RE: Application for Fill Permit, [REDACTED] Huntington Avenue
(ID # 2004-0248) (CBL# 410C001)

RE: Application for Fill Permit, 42 Huntington Avenue

Thank you for your application for a fill permit at 42 Huntington Avenue. Upon review of the site plan, the City has the following comments:

Drawing Name: **Lot 17 Grading Plan**

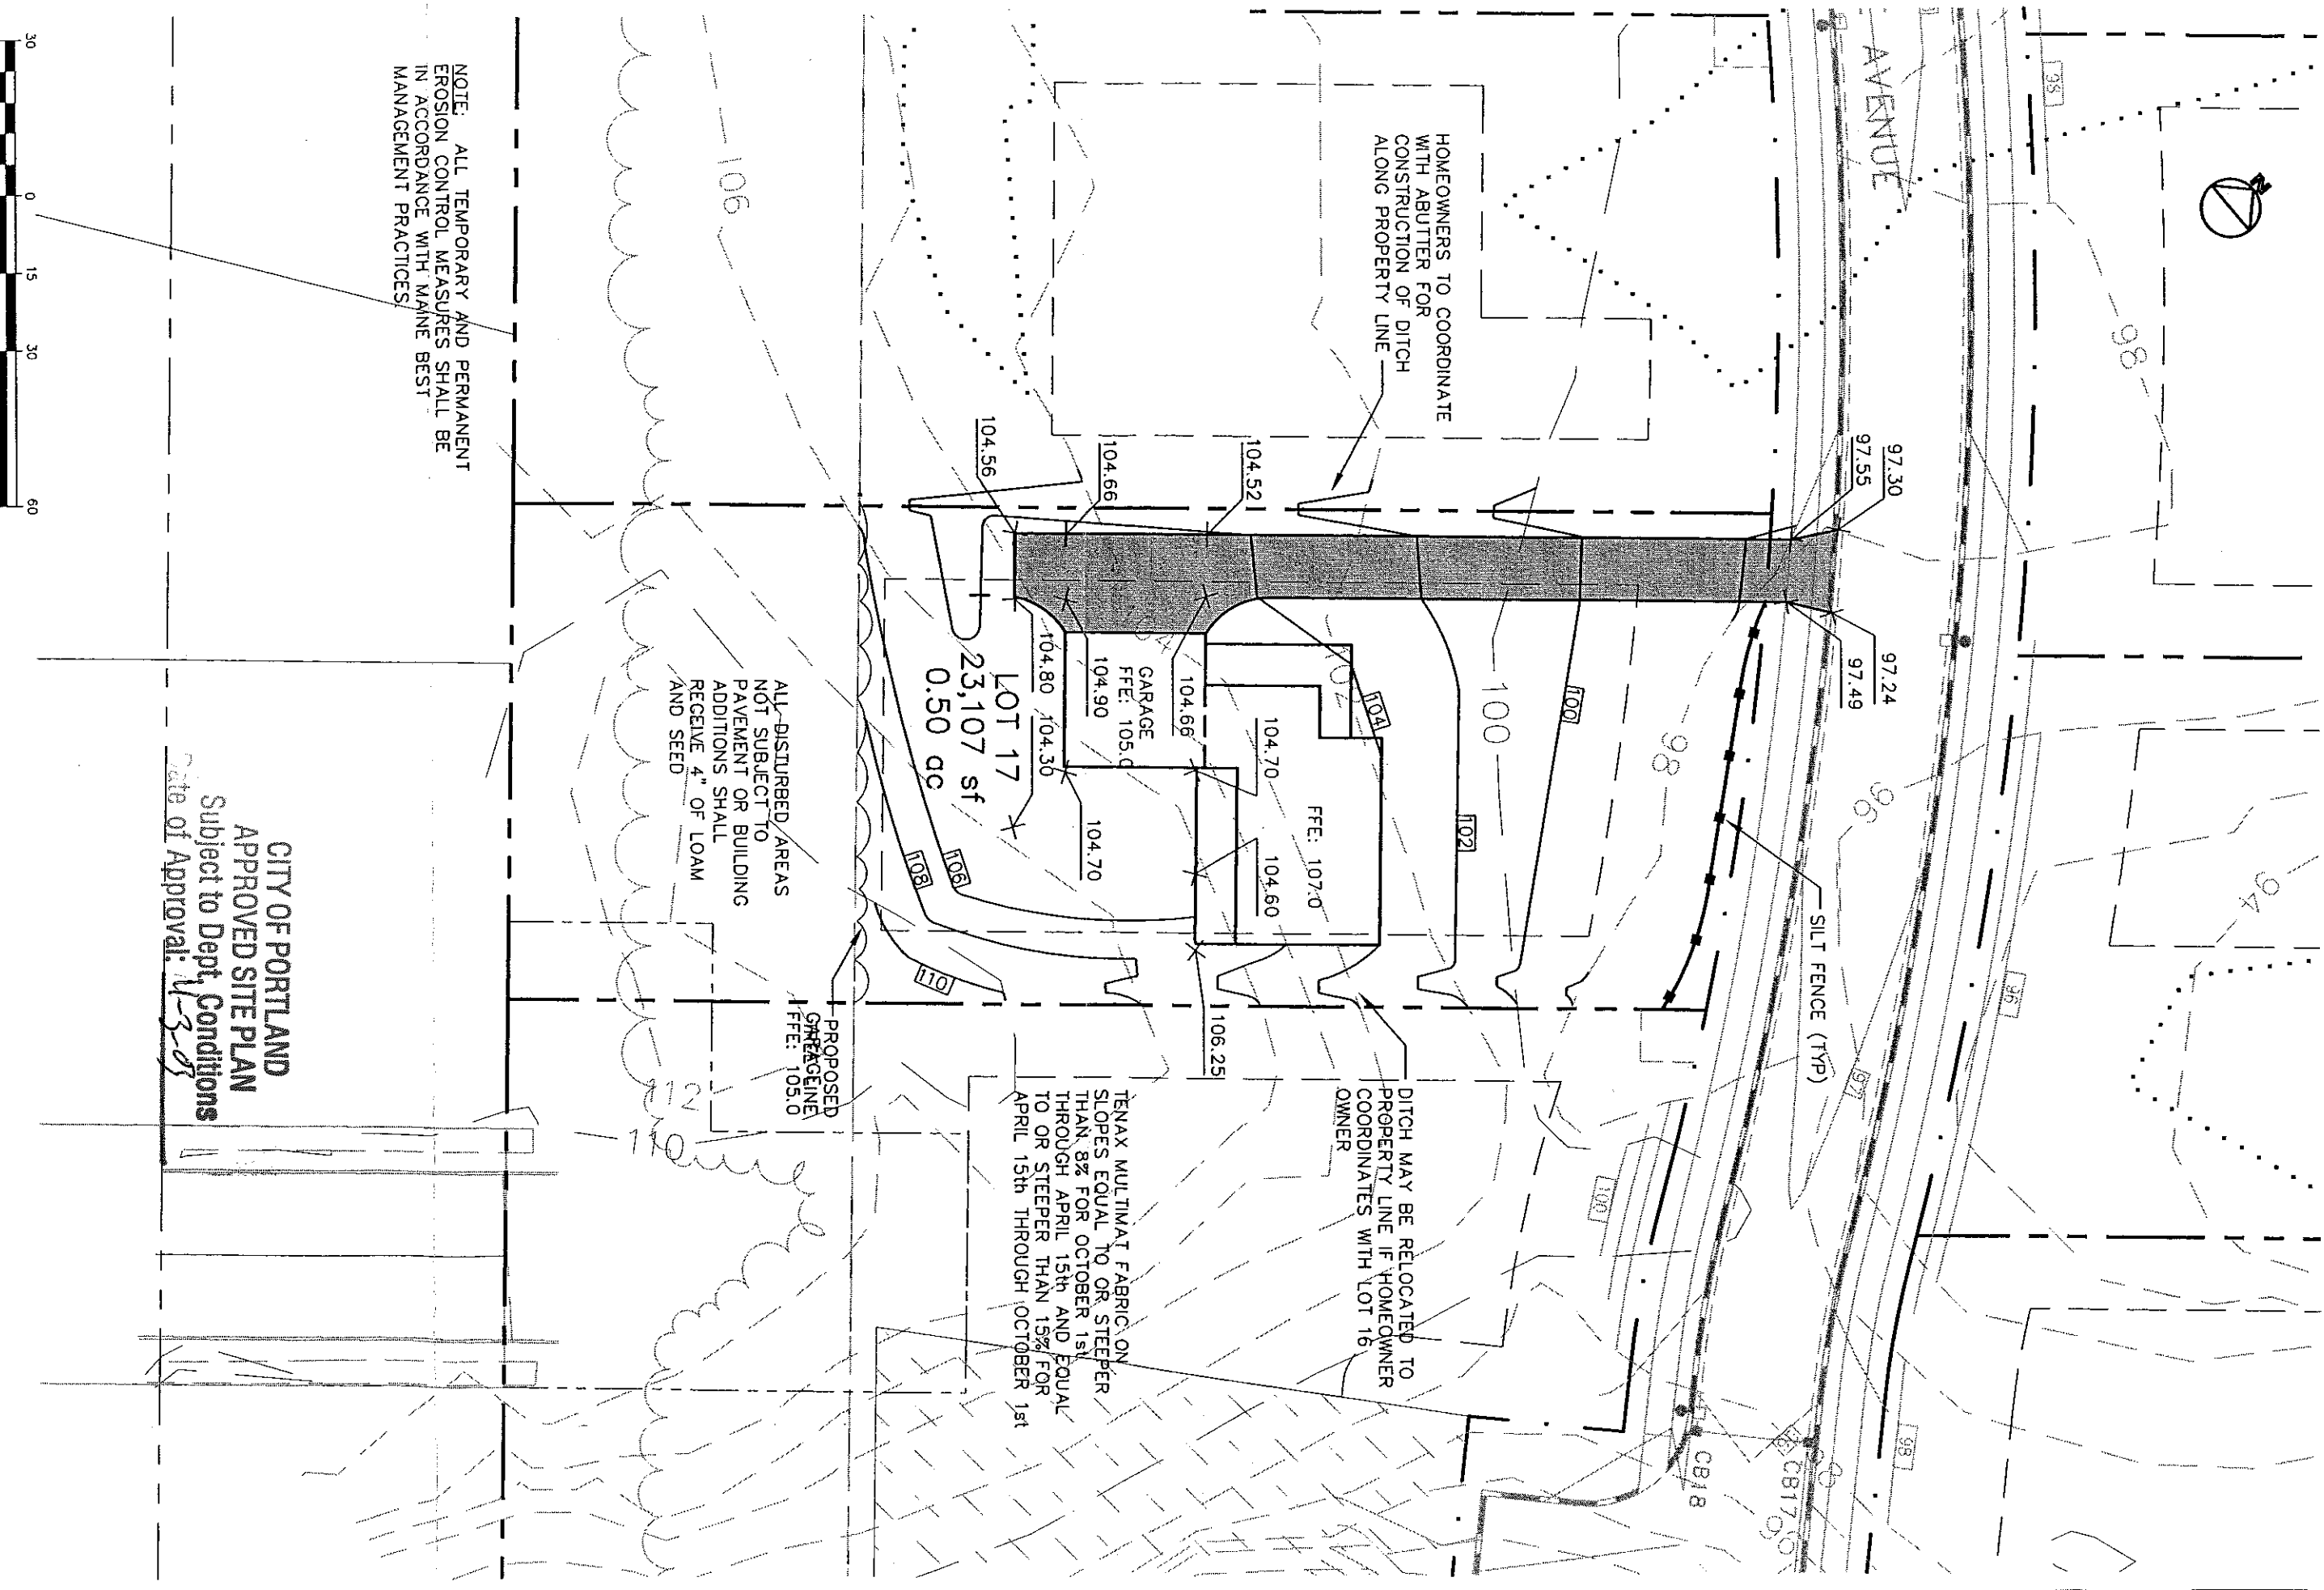
- W/oglast Structure -> J.S. To Email Detail
-> PWD to Provide Stub*
1. The Public Works department has recommended that a catch basin with a field inlet be installed along the Huntington Avenue curb line. Being that this drainage area only collects one or two lots, redesigning your swale to allow drainage over the existing curb may be a better and less costly solution. Please note which design you intend to proceed with on a revised set of plans.
 2. The drill holes in the granite curbing must be repaired (or replaced) to City standards. Please add this note to your site plan.

1. *The connection to the City installed field inlet shall be done with a 'Nylosplast drop in grate' (See detail attached), or approved equal.*
